Planning Services Sign Permit Review Form

Date of Submittal	Application Number	Applicant	Landowner
7/10/2024	SIGN2407-0002	Signs Unlimited	33418 Egypt Crossing LLC

The Bogey Brothers
2646 NC-87
Cameron, NC 28326

Channel Letters

Channel Letters - Raceway Mount

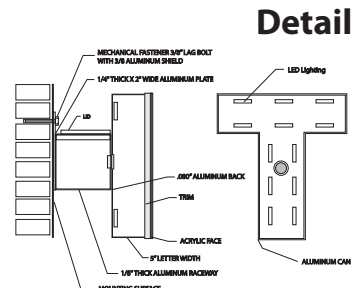
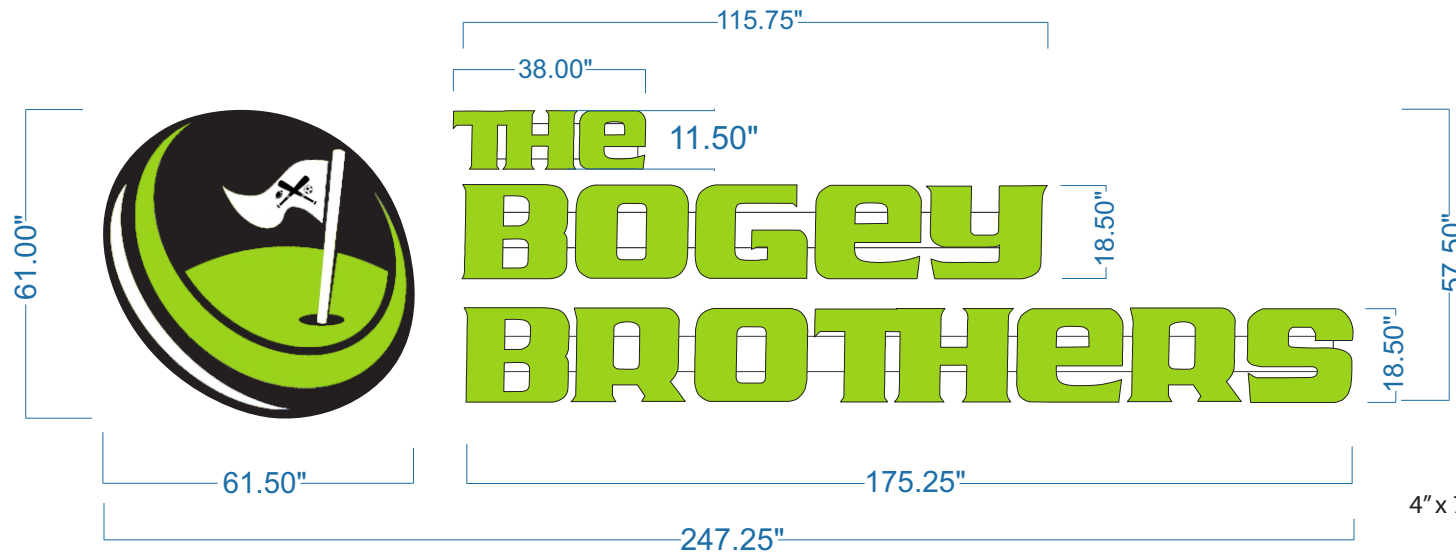
Comments	Signage permitted is calculated at a rate of 1 times the linear feet of the store front, which is 37'. Currently, 105 square feet is proposed.
----------	--
